June 5, 2006

**Re: Status of Improvement Permit Application #06-5-14925  
Lot # 165 Yorkshire Plantation**

06-500.14925  
Lot 165  
Yorkshire Plantation

LOT # 165 YORKSHIRE PLANTATION
SCALE: 1"-40'

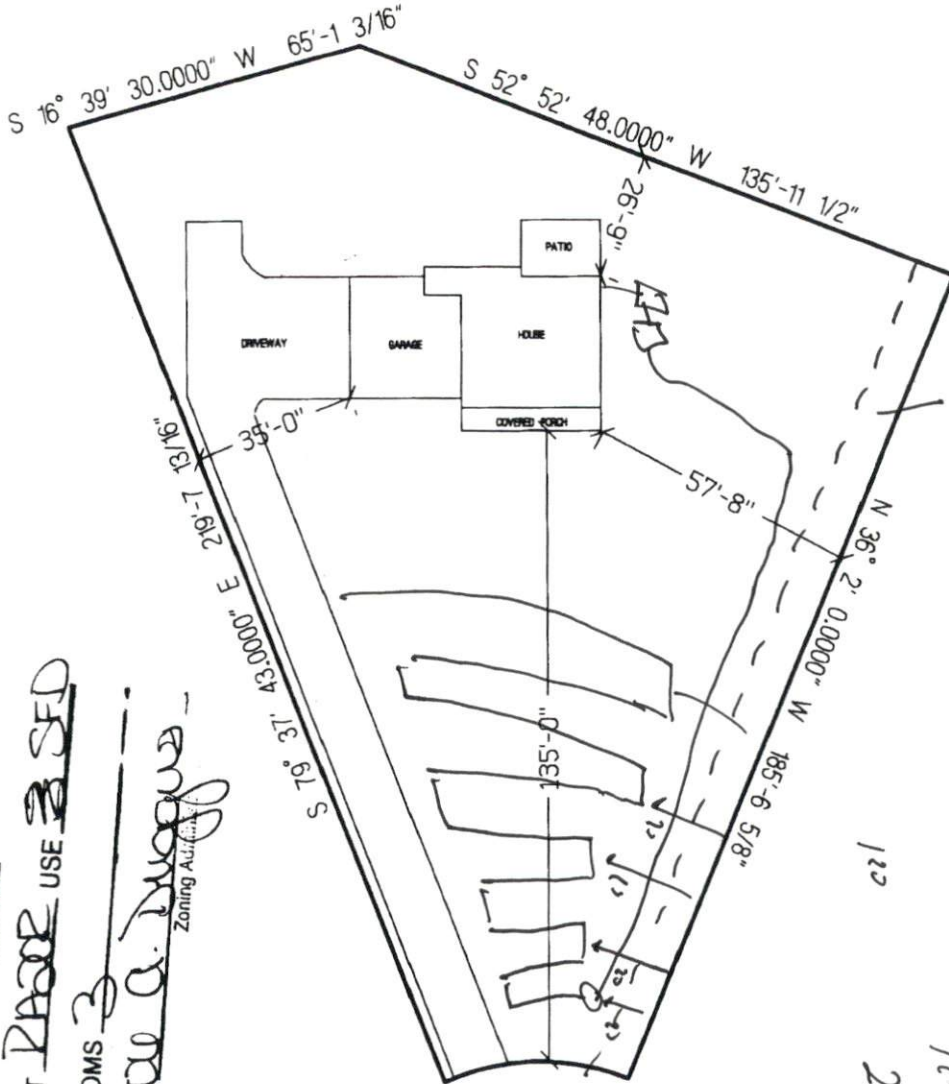
Mult Move how Back, Beyond shown set Backs  
Driveway must be along Property Line with Easement Along it  
Have to Be a Max of 10' Wide

**LOT # 165 YORKSHIRE PLANTATION
SCALE: 1"-40'**

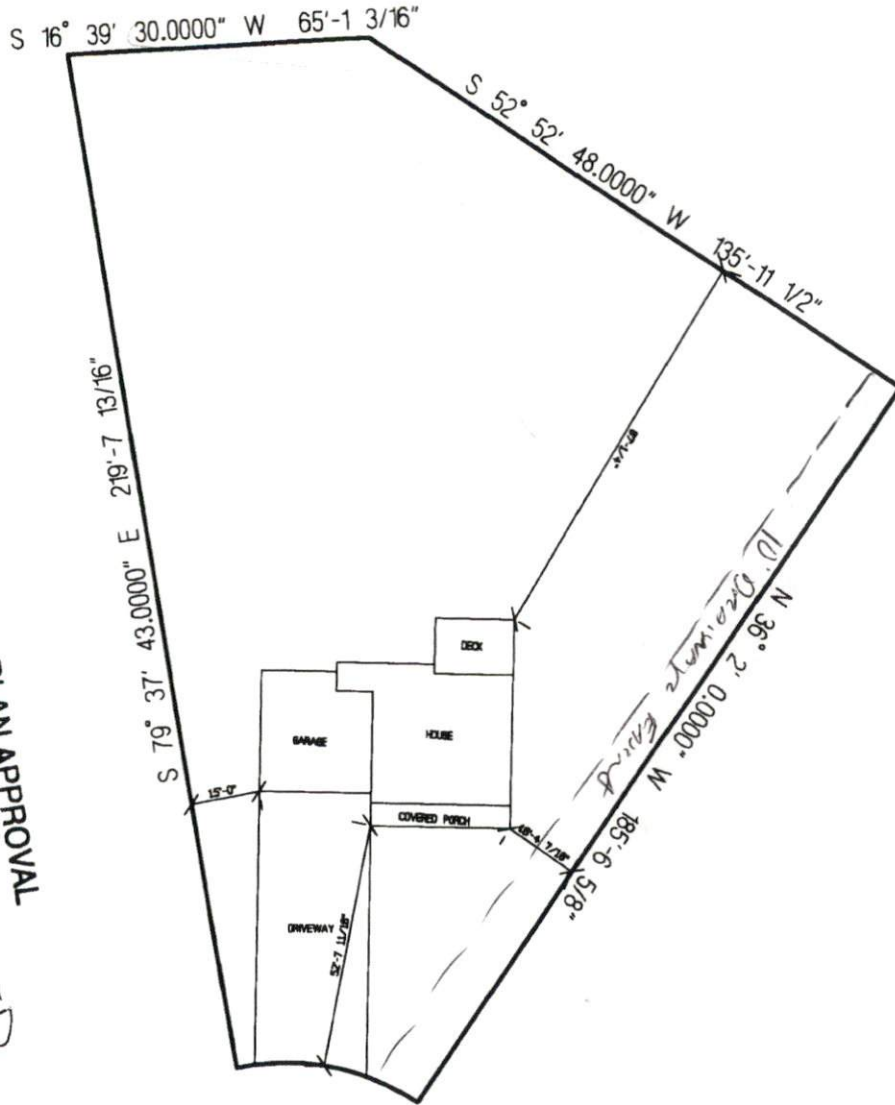
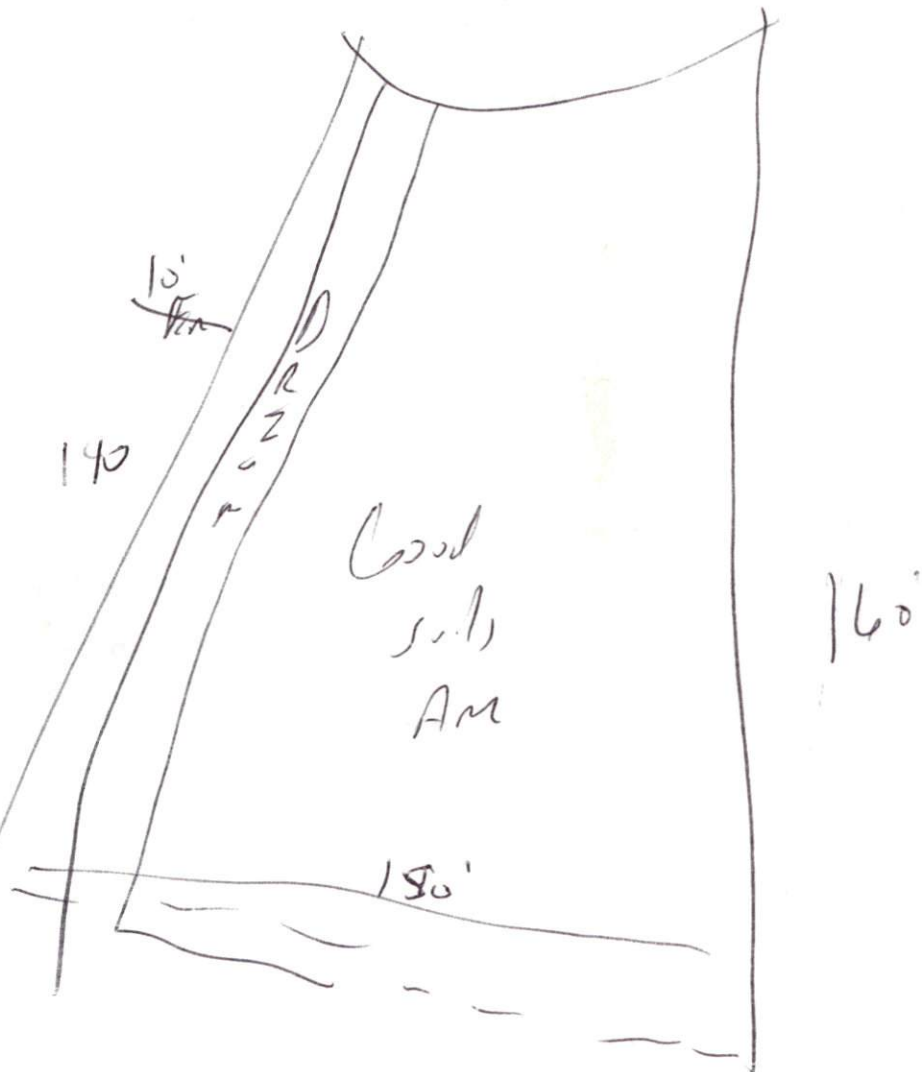
- 1. Property lines/corners not marked or labeled
- 2. House corners not marked or labeled
- 3. Directions not clear to property
- 4. Property needs brush or vegetation removed
- 5. Backhoe pits required
- 6. Other – **Must move house as shown on attached sheet. Please submit new plot plan to Central Permitting, as a revision, and reconfirm through the automated phone system.**
